Application No: BE/30/20/HH
Site Address: 1 Homing Gardens Bersted West Sussex PO22 9AJ
Description of works: First floor extension & re-positioning of boundary wall (Re-submission of BE/113/19/HH). This application affects the setting of a listed building & affects the character & appearance of the North Bersted Conservation Area.

OWPC26830

sheet 2 a of 5

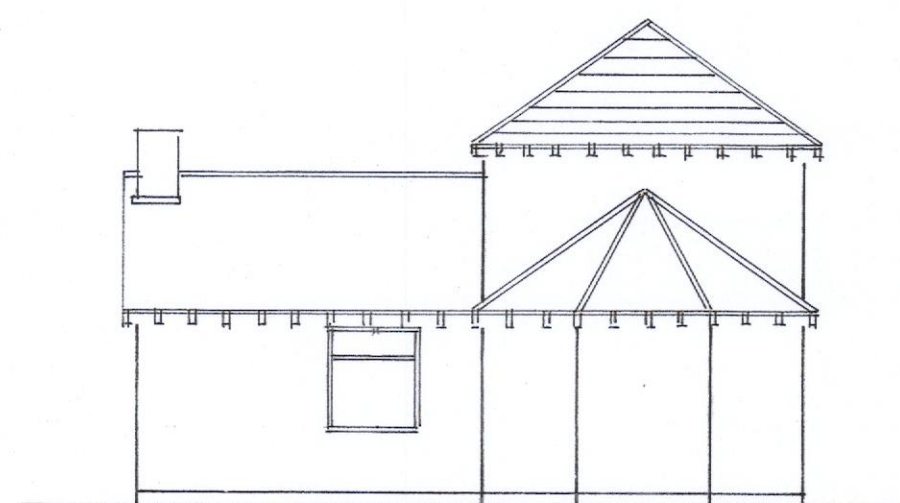
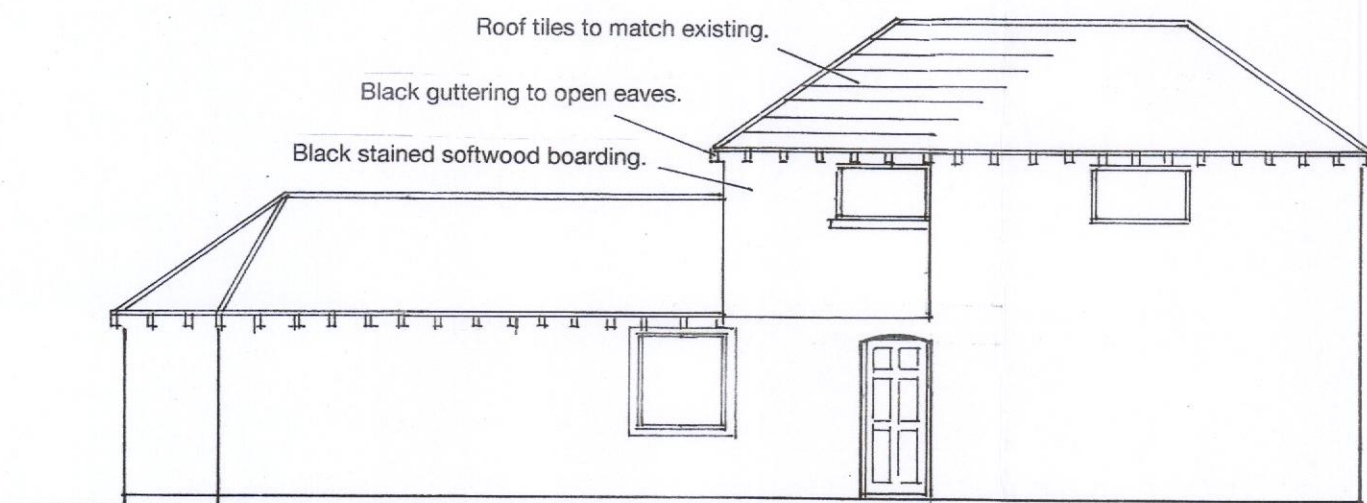
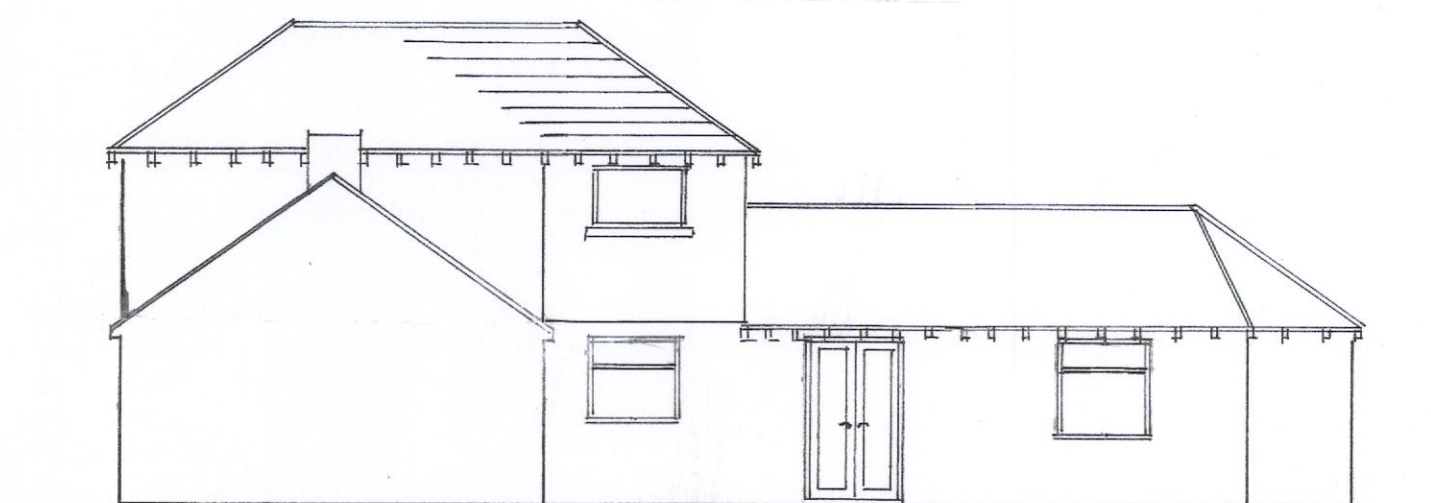
The amended plans have had the advice of the Conservation Officer and have reduced the mass of the building to something less obtrusive to the Conservation Area as a whole. Nevertheless, this is a sensitive area and a sensitive position within in the Conservation Area and it is regretted that cement boarding is to be used in the construction of the extension rather than tile hanging which would give some coherence to the area by echoing other modern building on the opposite corner. Should this extension be approved, consideration should be given to this rather than boarding.
